Ribble Valley Borough Council
Council Offices
Church Walk,
Clitheroe
Lancashire
BB7 2RA

Phone: 0300 123 6780
Email: developeras@lancashire.gov.uk
Your ref: 3/2026/0259
Our ref: 3/2026/0259/HDC/KW
Date: 07 May 2026

Location: Wharf Farm Green Lane Chipping PR3 2QE
Proposal: Proposed demolition of existing bungalow and outbuilding and erection of two storey detached self-build dwelling. Installation of ground mounted solar panels and creation of new vehicular and pedestrian access points
Grid Ref: 362405 443396

Lancashire County Council acting as the Local Highway Authority (LHA) does not consider that the application as submitted fully assesses the highway impact of the proposed development and further information is required as set out in this response.

drwg. no. 6567 /cb/101 date Nov-25 rev D

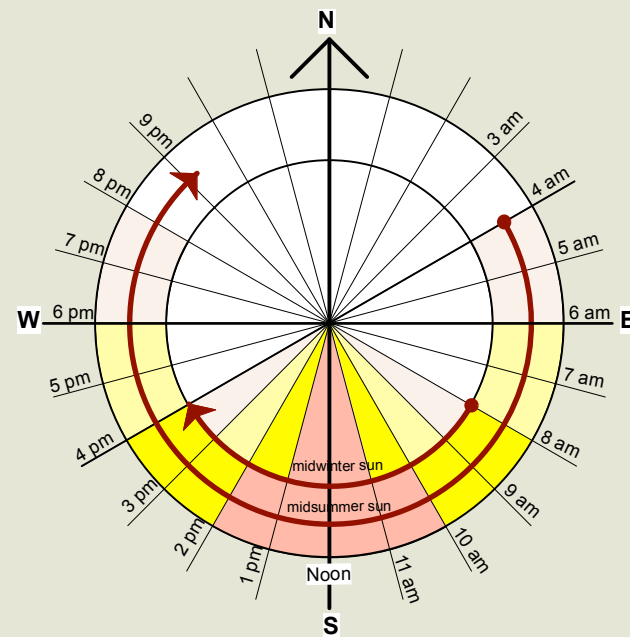
The site will be accessed via Burtholm Lane, which is classified as the C567 with a speed limit of 60 mph fronting the site access.

The access appears to have been improved between 2023 and 2025, where it has been widened, surfaced, and an access track created between the carriageway edge and one of the farm buildings within the wider site. The proposal will generate more car movements

and the drivers will not have the same sight line clearance over vegetation as the existing agricultural vehicles using the access. As such, the LHA would request that visibility splays be provided to ensure the access is safe and suitable.

To ensure adequate intervisibility between highway users at the access a visibility splays set 2.4 metres back from the near edge of the carriageway and extending 215 metres along the nearside carriageway edge in both directions should be provided.

The visibility splay should be wholly within the land which the applicant controls and/or the adopted highway and nothing shall be erected, retained, planted and / or allowed to grow at or above a height of 0.9 metres above the nearside carriageway level which would obstruct the visibility splay of the proposed access.

The applicant should provide accurate details of the sight line requirements before determining the application.

The LHA have reviewed the proposed site plan, drawing number 6567/c/b/101 and are aware that the dwelling complies with the LHAs parking standards as defined in the Joint Lancashire Structure Plan. There is also room to manoeuvre within the site, allowing vehicles to enter and exit in a forward gear.

Before determining the application, the LHA request that the application provides visibility splays for the access onto Burtholm Lane to ensure there is acceptable intervisibility between highway users.
